Dr. South's C.E. Primary School
Bletchington Road, Islip, Kidlington, Oxon OX5 2TQ
Faith, Hope and Love

Planning Application Ref. 14/00204/DISC

We are writing to object to Network Rail's application for the discharge of the planning condition (number 19) relating to section E of the Bicester to Oxford Rail Improvement. We do not believe that the basis for action set out in their application is complete and that there are relevant factors (set out below) which the planning authority should take account of before considering discharging the condition.

# Route Section E

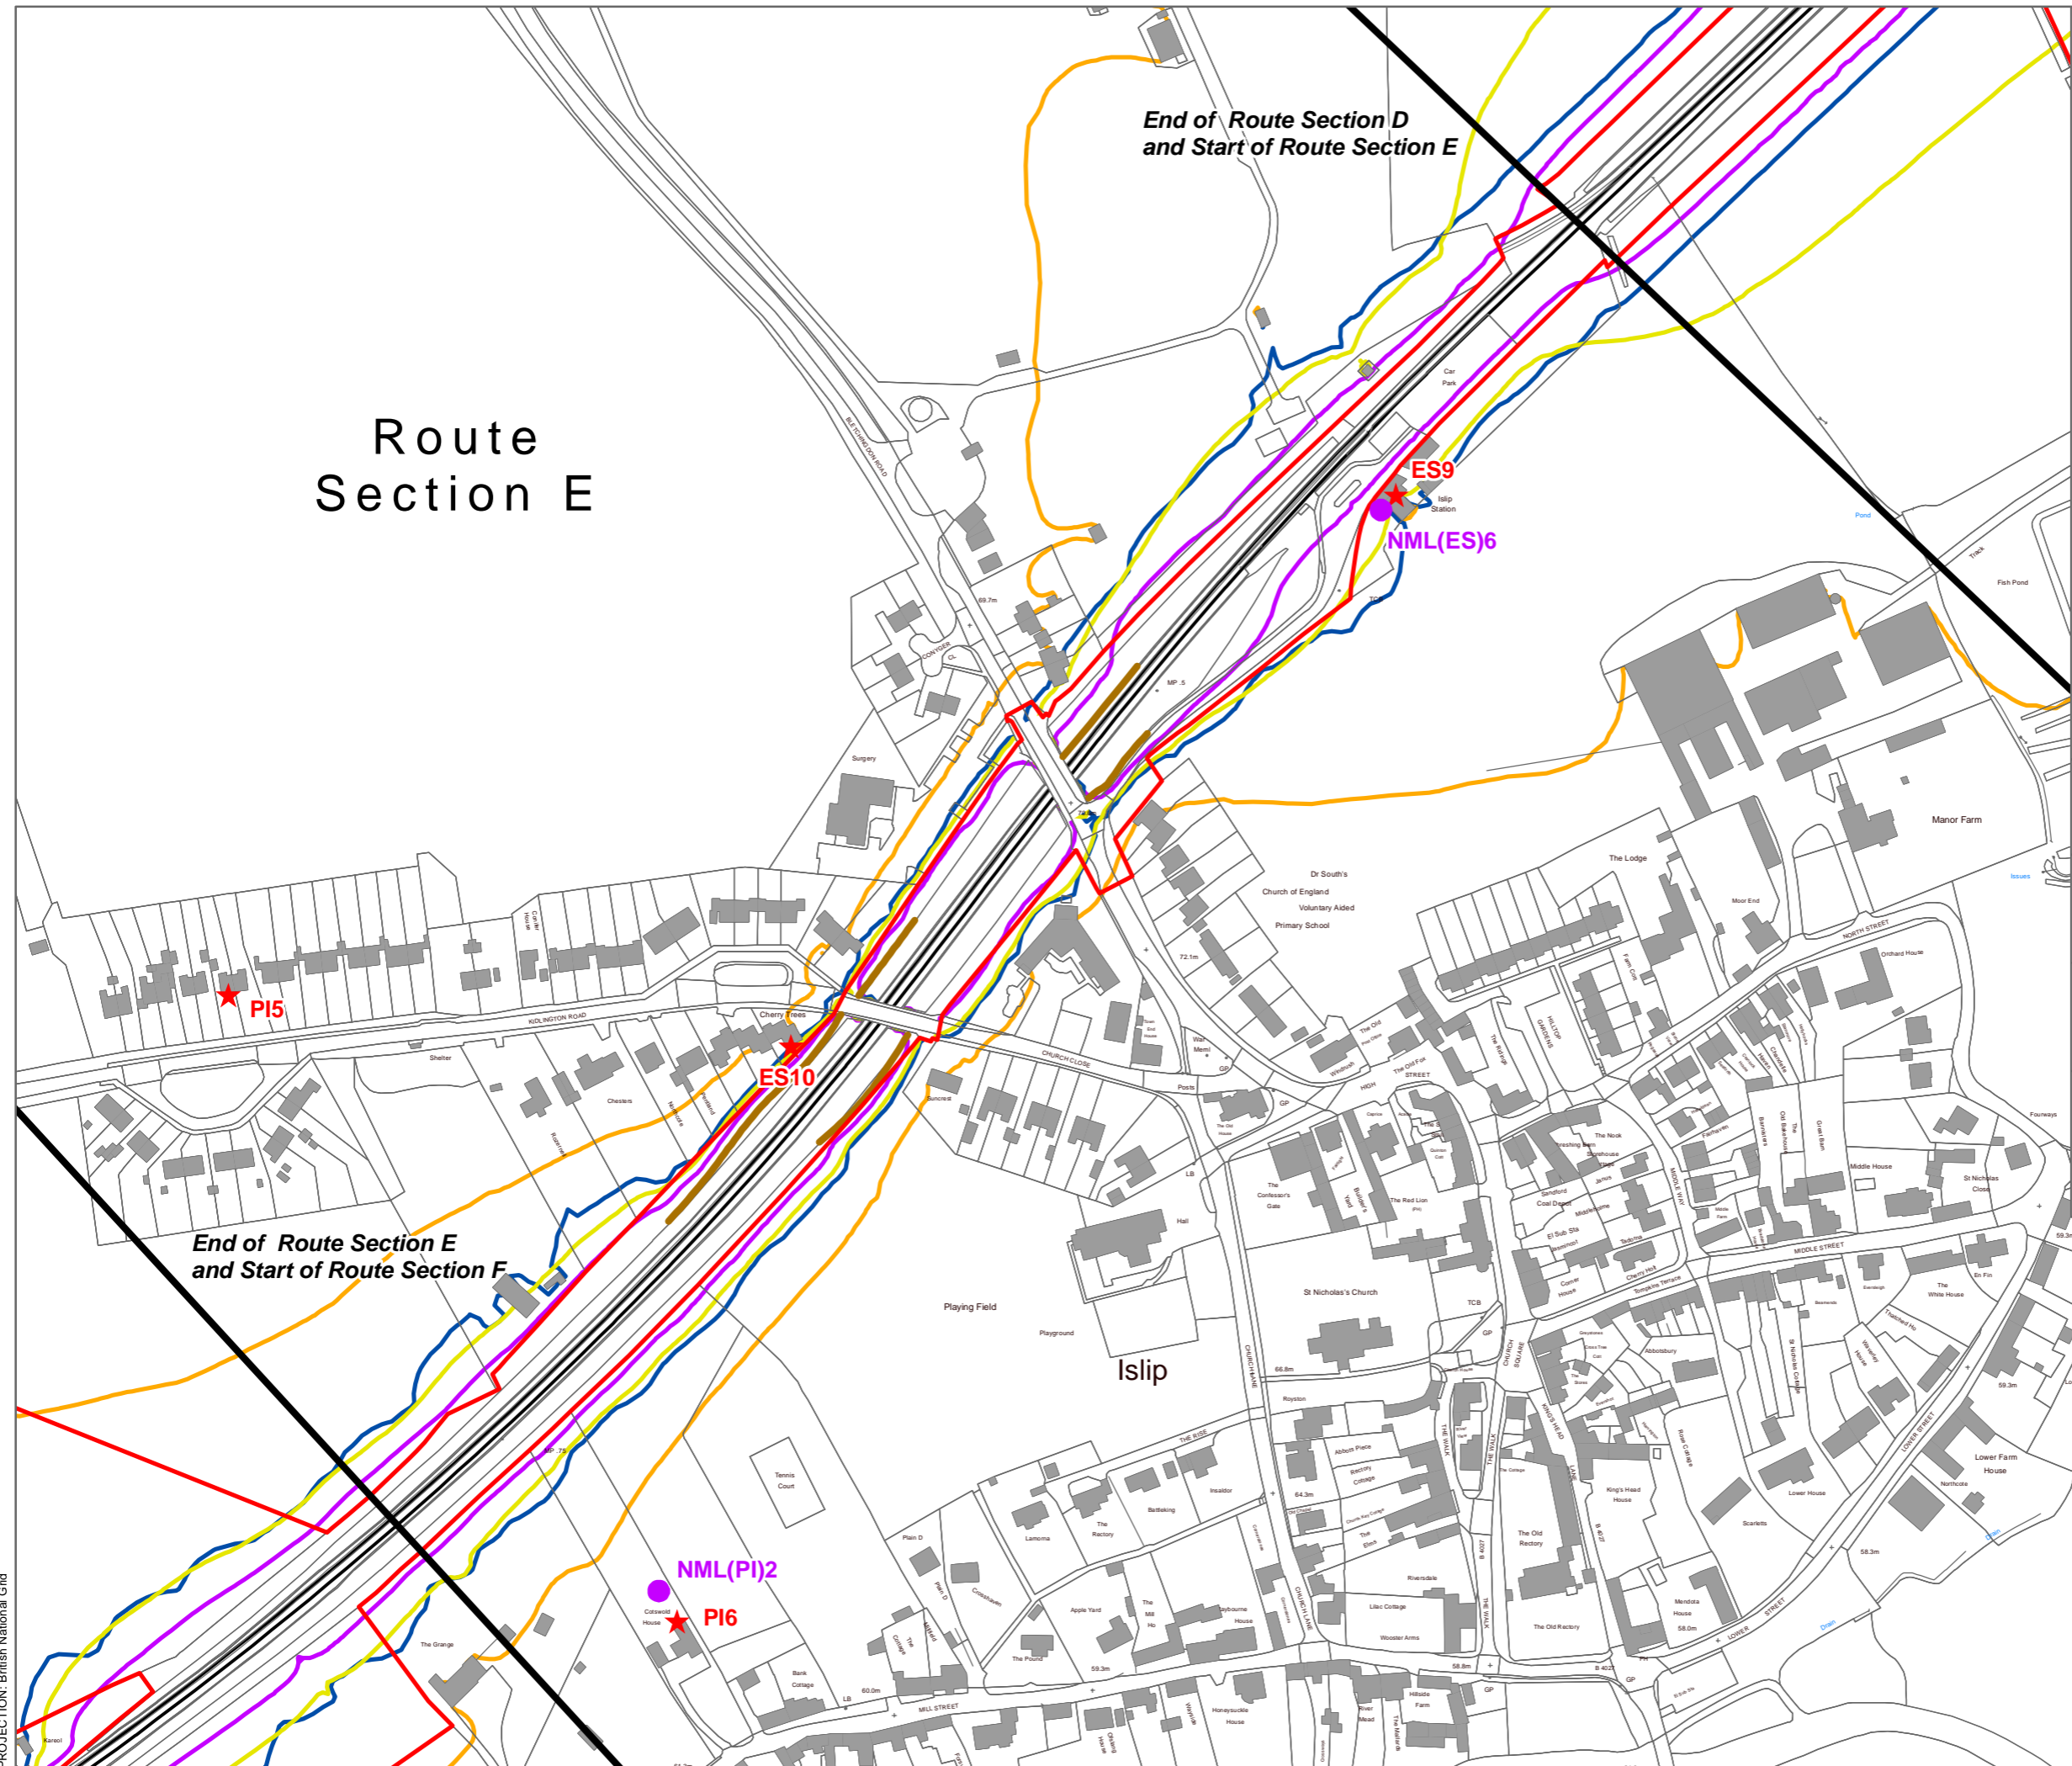
We have now had the opportunity to review the materials submitted by Network Rail to support its application for the discharge of condition 19 relating to section E. We note in the ‘Noise Scheme of Assessment’ that the applicant has commissioned ERM to produce a map of the noise and vibration impacts in Section E (page 21 of this report). This shows that the contours for a residual impact of $L_{Aeq,10dB}$ and a free field max level of L_{Amax} 82dB(A) fall within the boundary of the school. On the basis that these contours miss a classroom by a matter of centimetres we understand that Network Rail propose no noise mitigation for the school.

Second, we are very concerned that Network Rail have failed to take account of the fact that the school building is, in fact, an educational establishment. The map provided by Network Rail in their ‘Noise Scheme of Assessment for Section E’ is totally misleading on this point. The map carries the legend ‘Dr South’s Voluntary Aided Primary School’ in a field well to the east of the actual school site, with no line or indication of where the school is, in fact, located (in the triangle between the railway and the Kidlington and Bletchington Roads). Furthermore, Network Rail’s Noise and Vibration Mitigation Policy paragraph 2.2 states ‘*The Promoter is committed to using the Best Practicable Means (1) to design the railway so as to*
